MEMORANDUM

EPC Project No.: PPR2315

Re: Super Star Carwash – Claremont Business Park 2 – Drainage Compliance Letter

C5.2

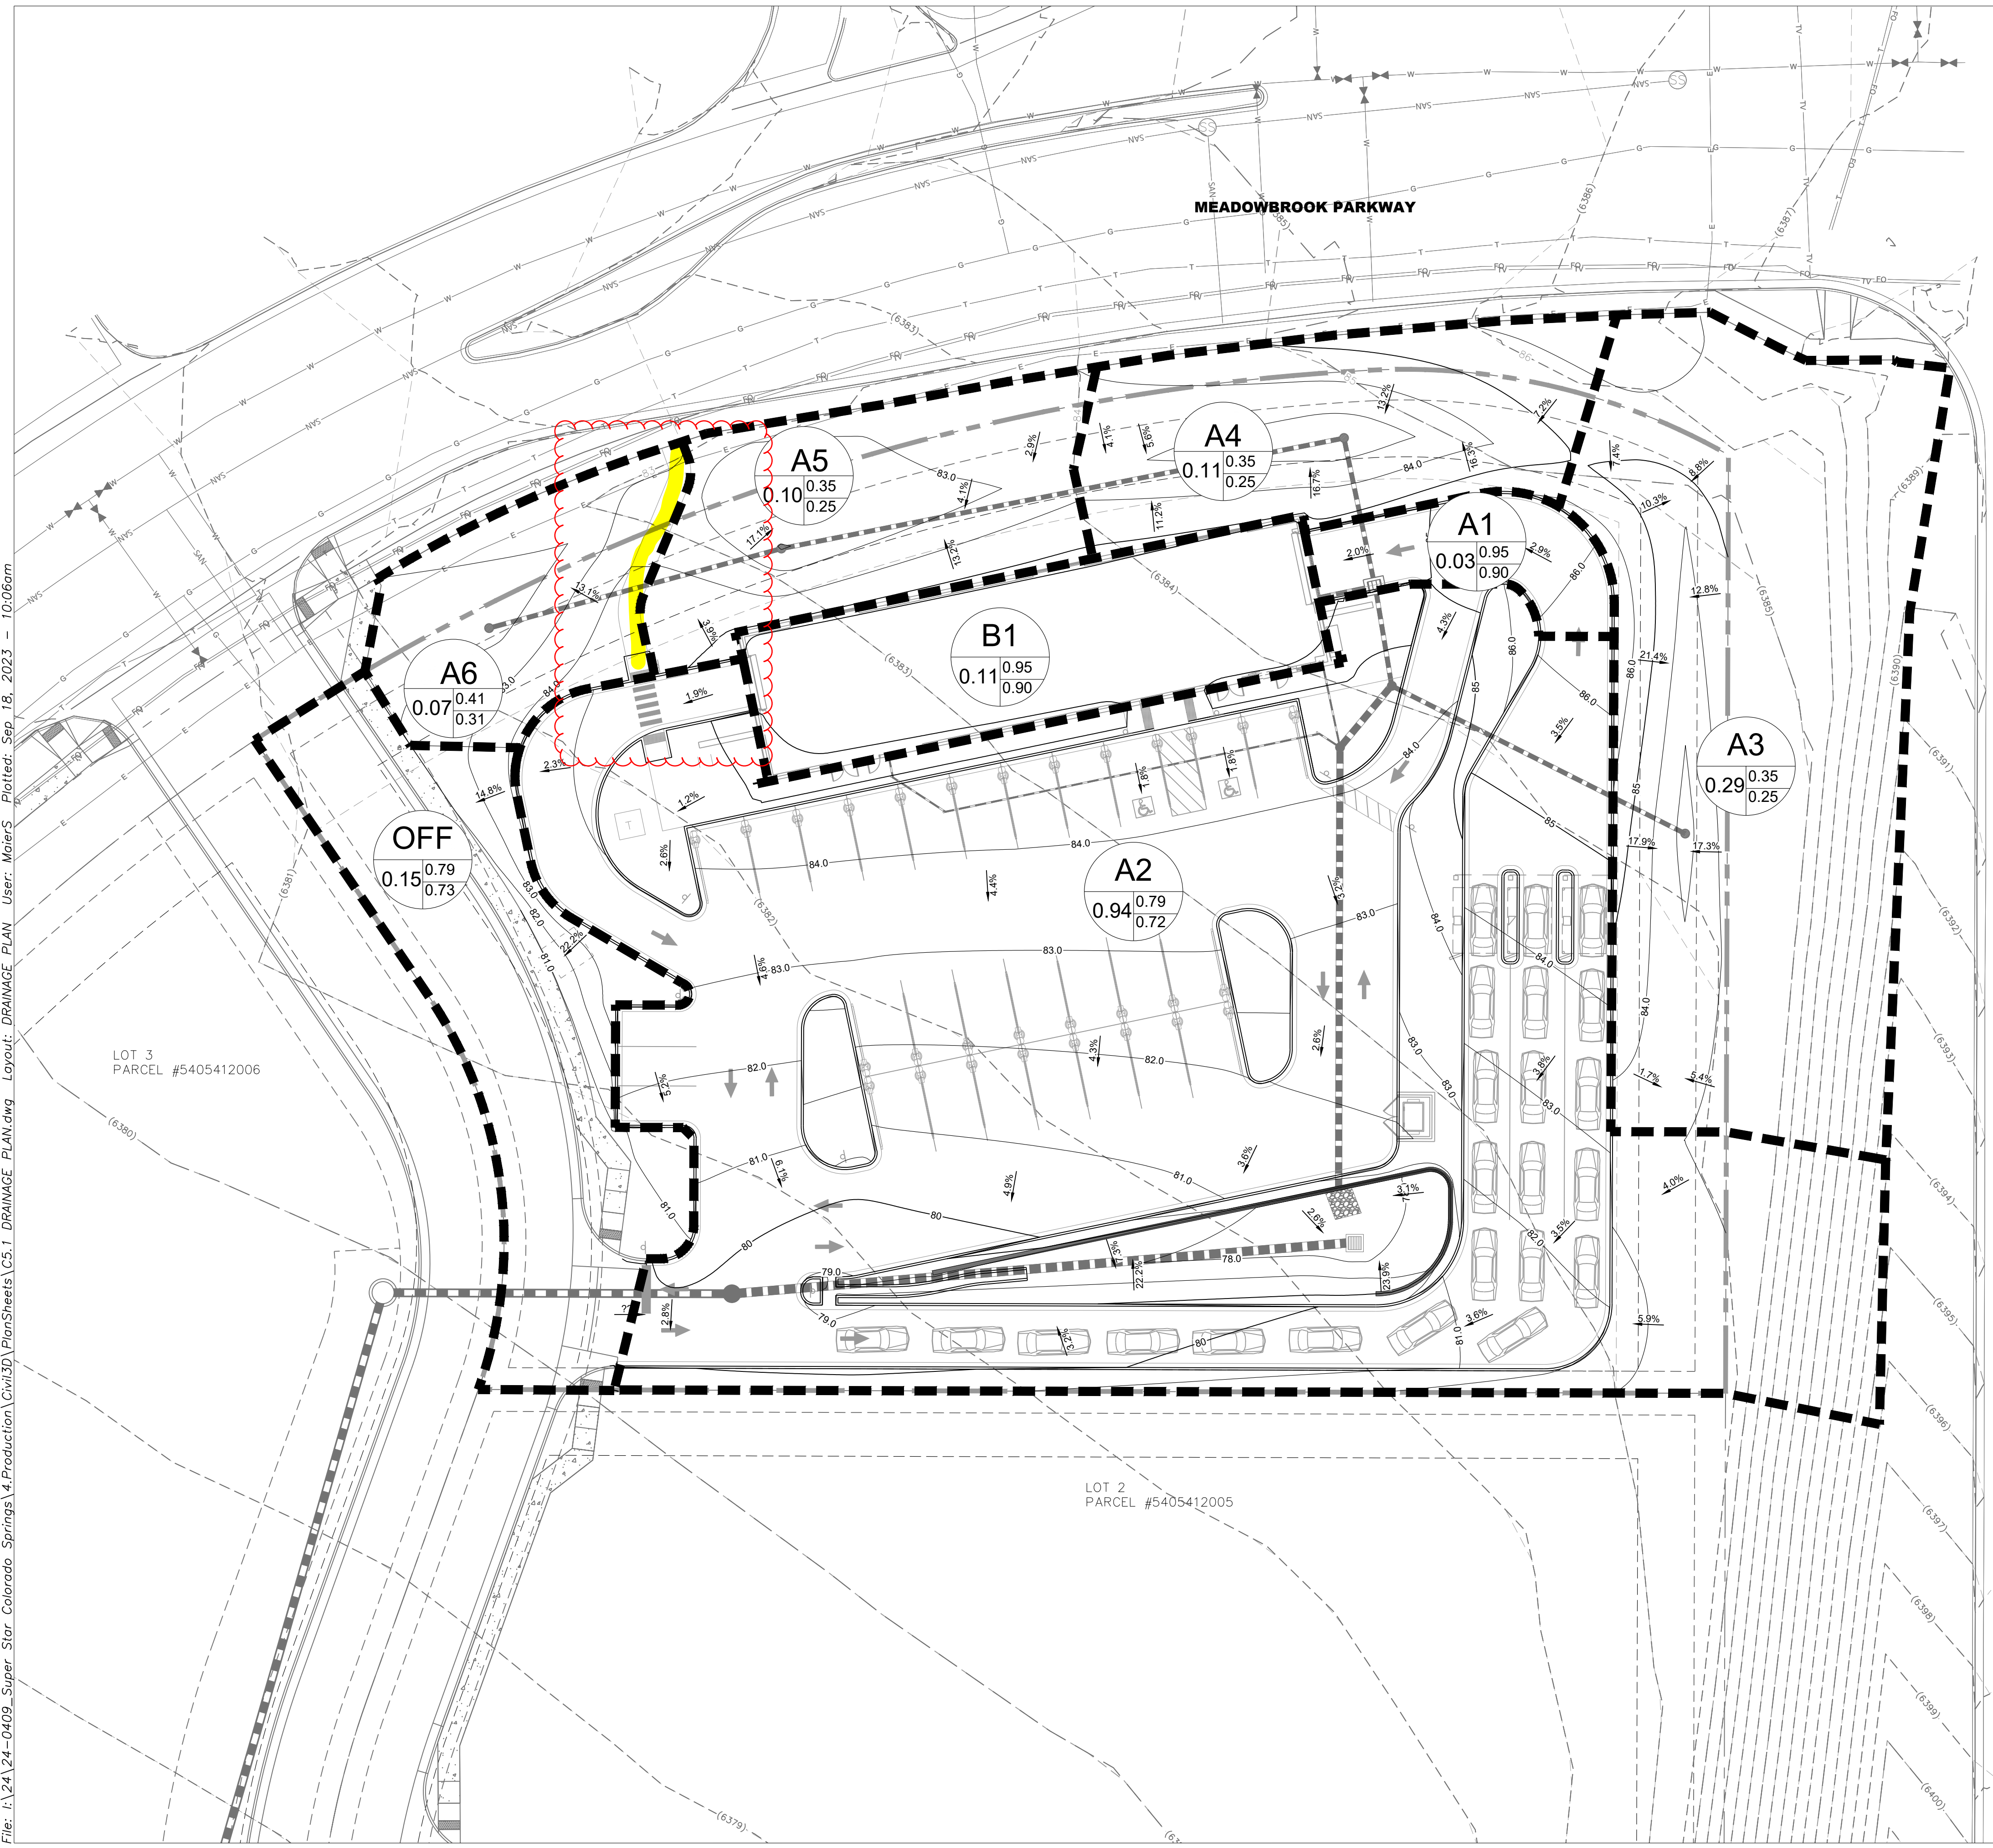
Explain where the site flow will go to a suitable outfall.

Please update report in accordance with ECM 4.5
The FDR for VR233 has not been approved yet.
Please include drainage map showing basins for the lot
